6th April 2021

Application No: FG/16/21/PL
Site Address: 1 Phoenix House Ferring Grange Gardens Ferring BN12 5HS
Description of works: Conversion of garage into bedroom & replace existing conservatory roof to solid roof with Velux (resubmission following FG/144/20/PL). This application affects the character & appearance of the Ferring Conservation Area.

PROJECT Chambers ,No.23	DRAWING NO. 1459-P301	SCALE 1:100 @ A3	27 Oct	A 2020	
ADDRESS No.23 Heathfield Close Worthing	DRAWING TITLE Proposed Elevations	DRAWN BY CRE8TIVE LINES - ROZ NOWAK			
RICT COUNCIL FG/16/21/PL BN13 1LJ

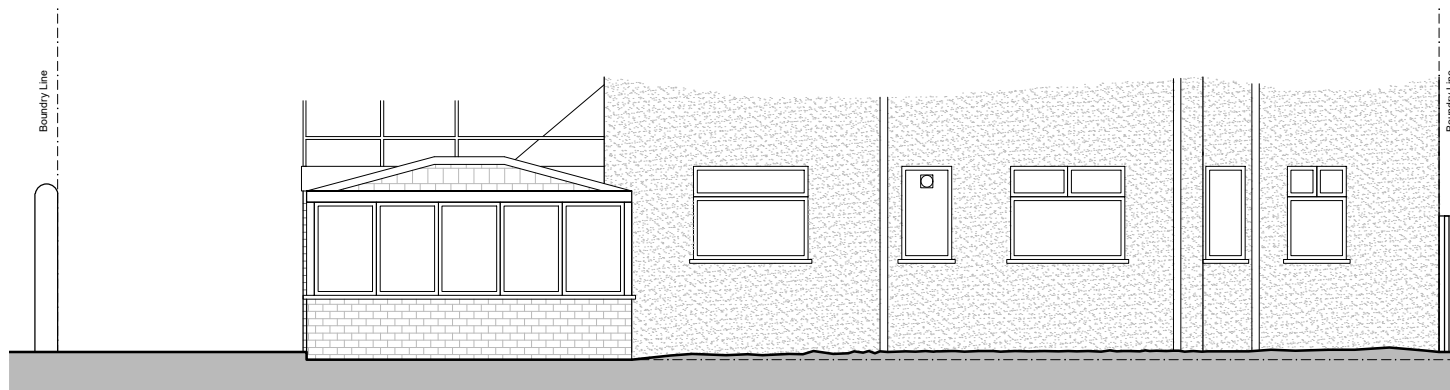
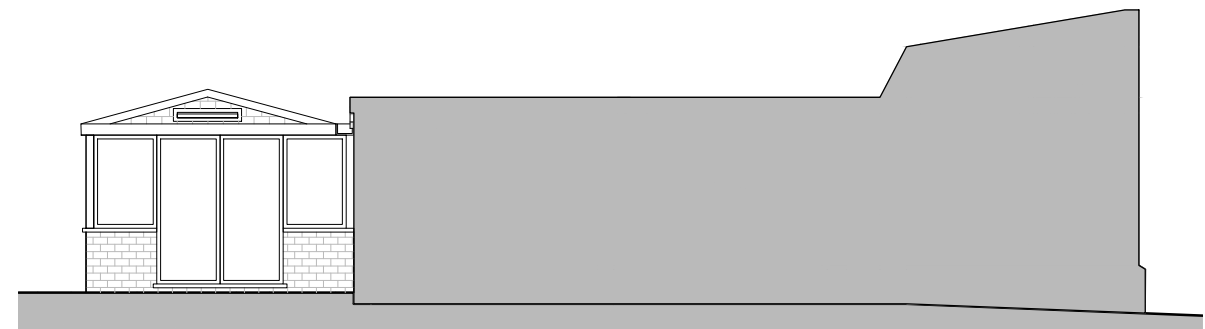
This application will not harm the conservation area. The Panel suggest prior submission should be made regarding the materials to be used for the wall replacing the garage-door & the window-frames plus the Conservation-style Velux window & tiles to be used re. the new conservatory roof.
